CITY OF ALBUQUERQUE

August 15, 2013

**Re: GAHH Relocation and Tenant Improvements, Habitat for Humanity
Restore, 4900 Menaul Blvd. NE, Traffic Circulation Layout
Architect's Stamp dated 8-13-13 (H17-D110)**

Based upon the information provided in your submittal received 8-14-13, the above referenced plan cannot be approved for Building Permit until the following comments are addressed:

No.	Description	Date
20_1225	CAD DWG FILE: DWL-NM_RESTORE	
	DRAWN BY: B. RAEL	
	CHECKED BY: R. BURTON	
	SHEET TITLE: TRAFFIC CIRCULATION PLAN

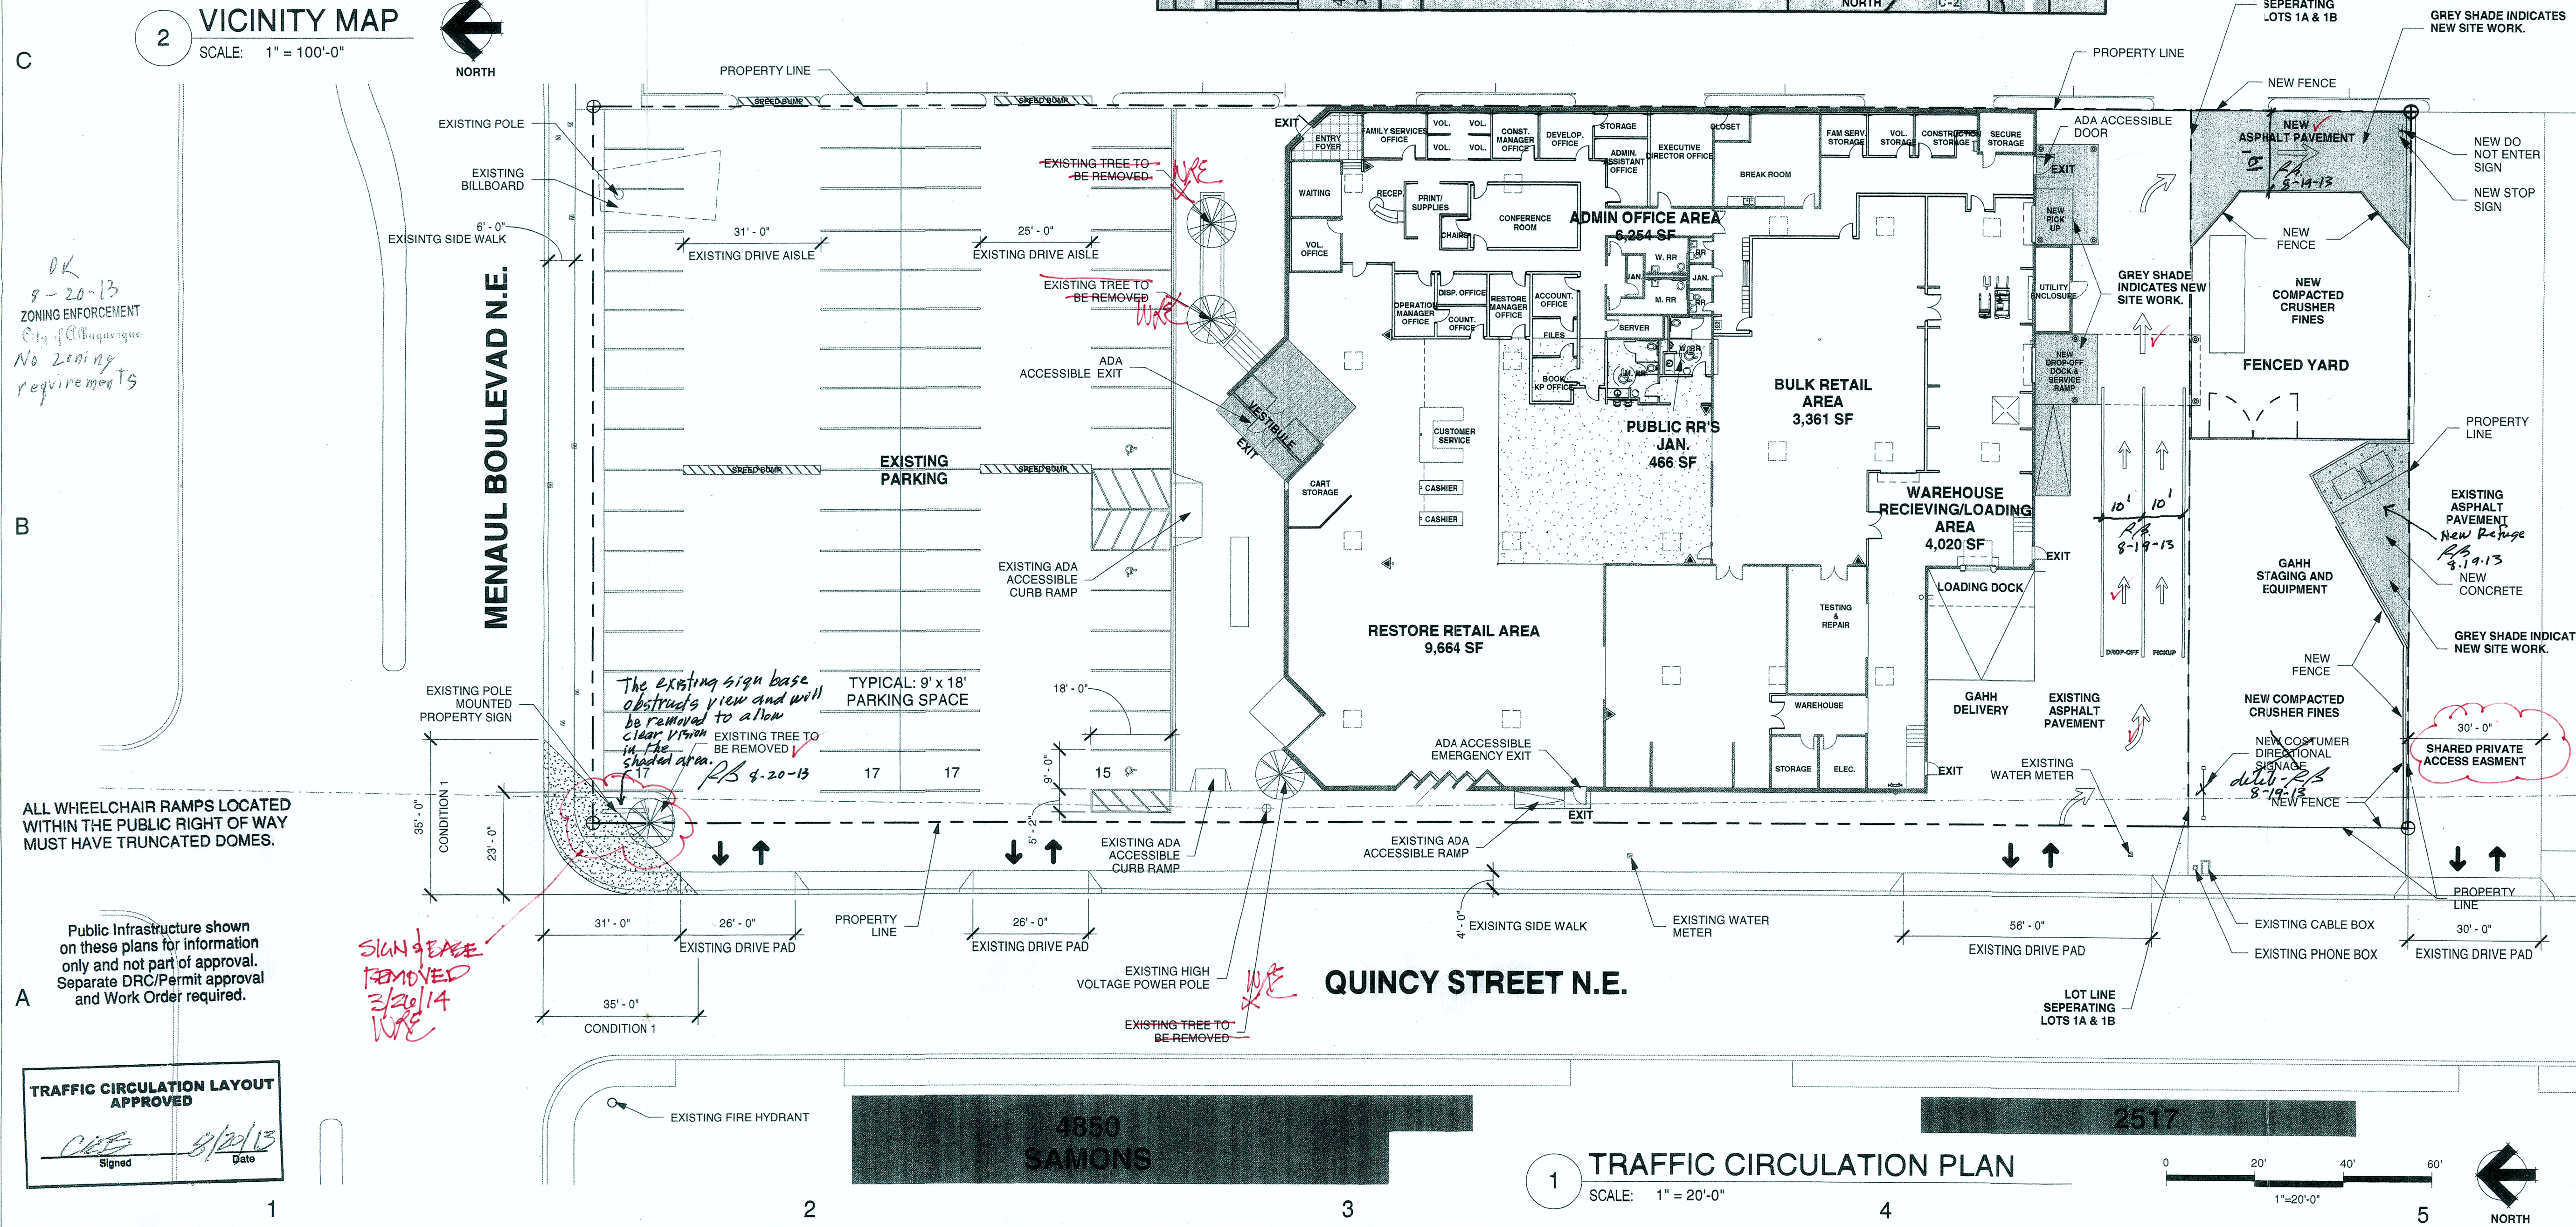
1. Please show a vicinity map.
2. Please provide the legal description of the site.
3. Please provide a line-type legend.
4. Please label, dimension and detail all line-types, distinguishing between existing and proposed (include any refuse area, fences, walls, gates, ramps, railings, speed humps, landscaping, signs, property lines, pedestrian paths, curbing, fire hydrants, light posts, support posts, overhang structures).

5. The site appears to be composed of two lots (1A & 1B4) with the shared private access easement within lot 1B4. Please clarify lot lines.
6. Please include a copy of your shared private access easement with the adjacent property owner(s). There are several shared access points from the site, are there shared access agreements for each location?

7. Will site be replatted to consolidate lot lines?
8. Please list the width and length for all parking spaces.
9. List the number of parking spaces required by the zoning code as well as the proposed number of parking spaces.

10. The handicapped spaces must be a minimum of 8.5 feet in width.
11. The handicapped spaces must include an 8-foot wide van access aisle; all other aisles should be 5 feet in width.

12. Define width of the existing sidewalk.
13. Pedestrian walkways shall be provided from all street sidewalks to the principal customer entrance(s) on the nearest building(s) on a site. The path(s) must be ADA accessible, clearly demarcated, six feet minimum width and not located behind parking stalls.

14. Please refer to all applicable city standards.
15. Please ensure all ramps are ADA compliant.
16. List the width of the existing drivepads.
17. List the widths of parking lot drive aisles, drop-off lanes and exit drive.

18. One-way orientation requires posted signs and pavement markings to guide vehicles.
19. Per Chapter 23, Section 6, Part B.5 of the City of Albuquerque *Development Process Manual*, any drive on a local roadway that is intersecting with a minor arterial must be located a minimum of 50 feet from the intersection. Please provide the distance the drivepad on Quincy is set back from the intersecting point with Menaul Blvd.

20. Show the median break on Menaul Blvd in reference to the site?
21. There appears to be existing signage along the Menaul Blvd. frontage. Signage must not encroach onto COA right-of-way, including air space, without a Revocable Encroachment Agreement.

22. The apparent signage along the Menaul Blvd. frontage must not interfere with the sight distance of the intersection. Please provide a sight distance exhibit (see the *Development Process Manual*, Chapter 23, Part B, Section 5.a).

23. Per the Development Process Manual, Chapter 27, Section 7, Part F.II, a scale of 1"=20' is recommended for sites of less than 5 acres.
24. A scale must be shown on the plan. Per the Development Process Manual, Chapter 27, Section 2, Part B.1, only the following scales may be used:
 - 1" = 50'
 - 1" = 40'
 - 1" = 20'
 - 1" = 10'
 - 1" = 100' (for overall layouts only).
